Our ref: SSD7445

**State significant development application for a mixed use development at
Site 9, Sydney Olympic Park (SSD 7445)**

SCHEDULE 1 – ISSUES AND ADDITIONAL INFORMATION

APPENDIX I – EXISTING SERVICES

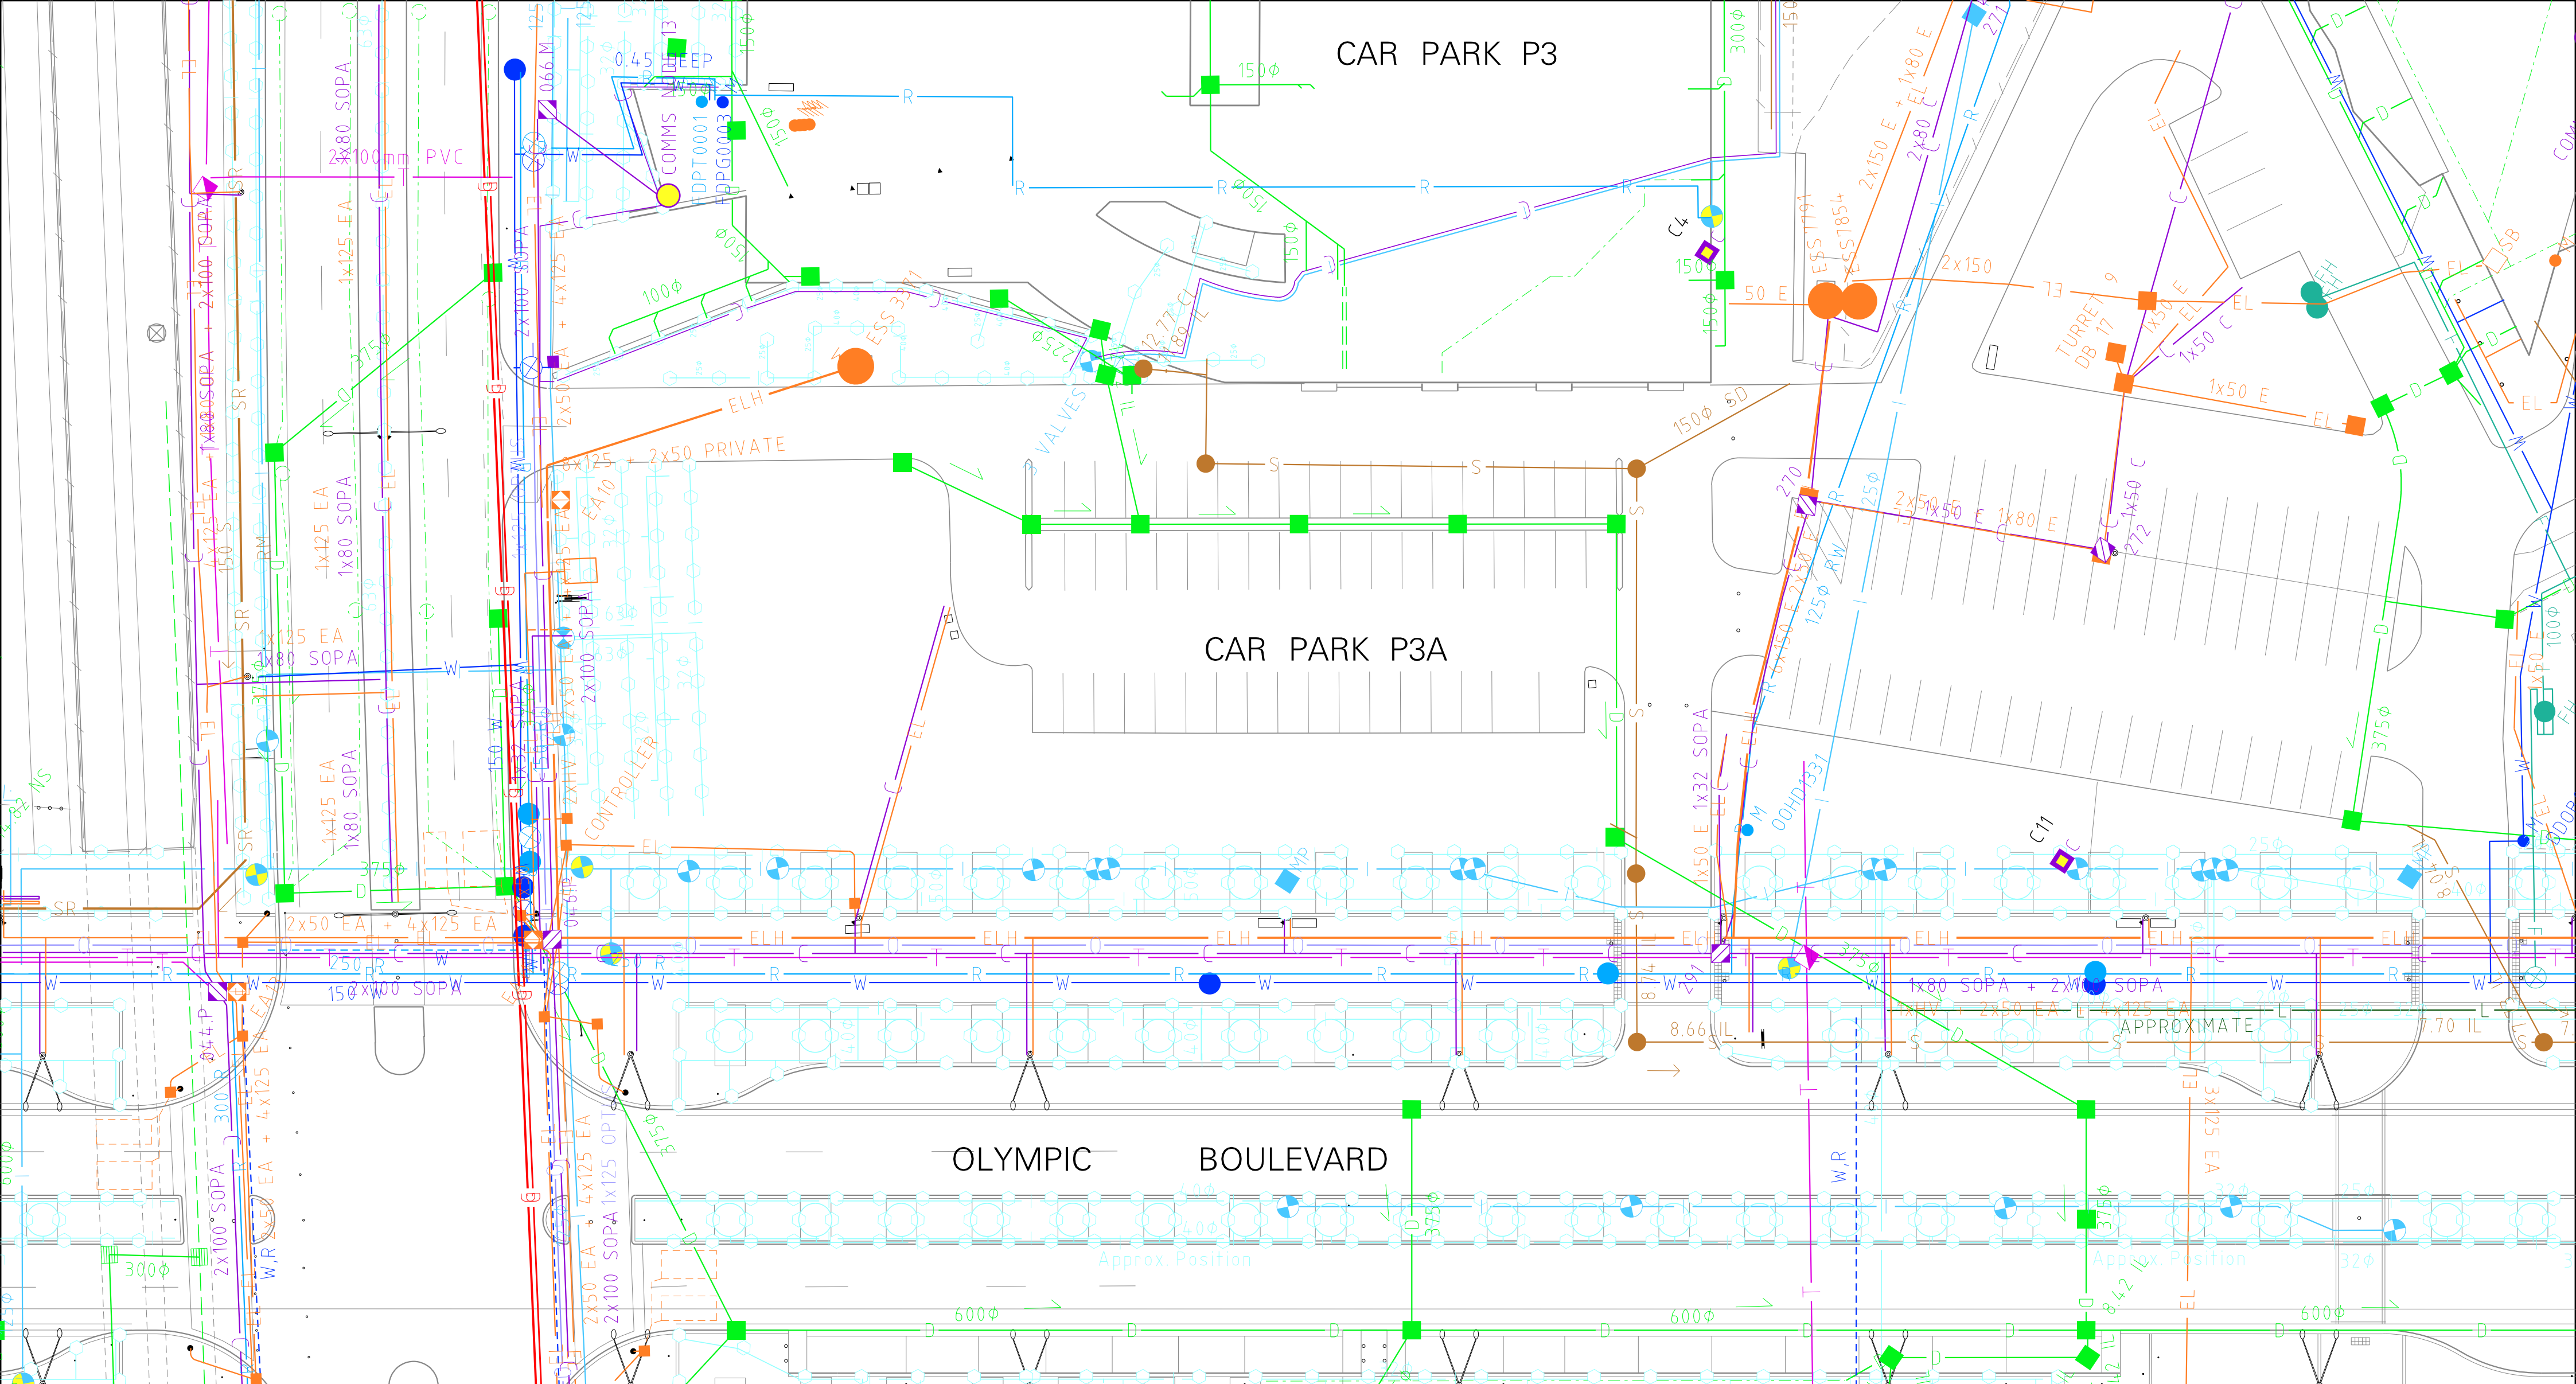
- Provide details showing the location of the waste water mains that traverse the site and options for how these assets may be protected.
